OUT19/16062

**Snapper Mine Northern Extension - MOD 7 (MP06_0168-Mod-7)
Modification Report**

Simon Francis
Senior Policy Officer, Assessments
Water - Strategic Relations
21 February 2020

TRONOX
S N A P P E R M I N E
Location of Groundwater
Monitoring Sites

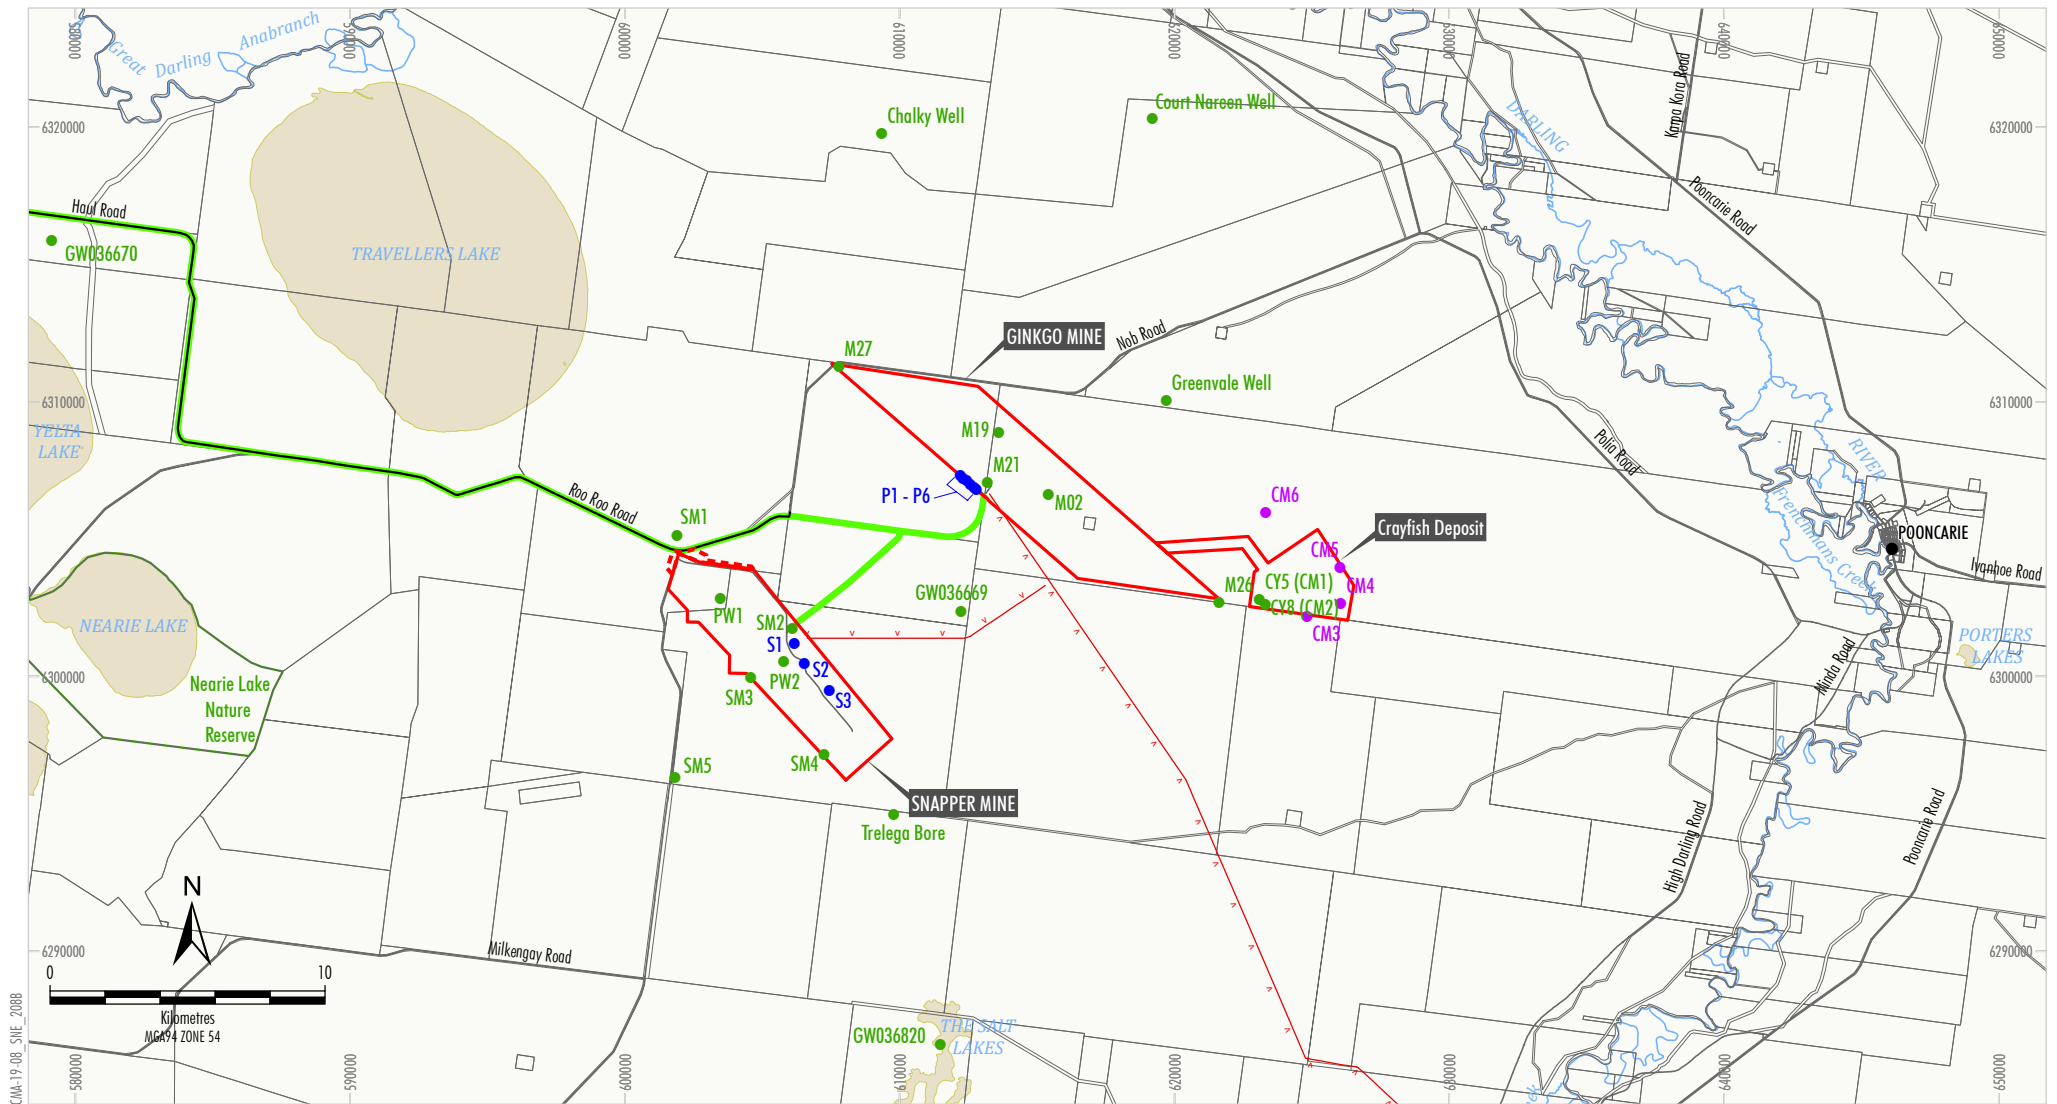
2. Appendix F Section 2.7 Table 1 includes Tronox-owned monitoring bores and their schedules however does not include SM1. SM1 is located north of the mine path and is predicted to have a decline in the water level of the upper aquifer. SM1 should be included in Table 1.

2. The schedule for monitoring (Appendix F, Section 2.7, Table 1) should include bore SM1.
3. The proponent should provide a calculation of evaporation loss as a result of the Project.
4. The proponent should provide a calculation of the increase in infiltration volume due to infiltration in the final depression associated with the dredge pond at cessation of mining.
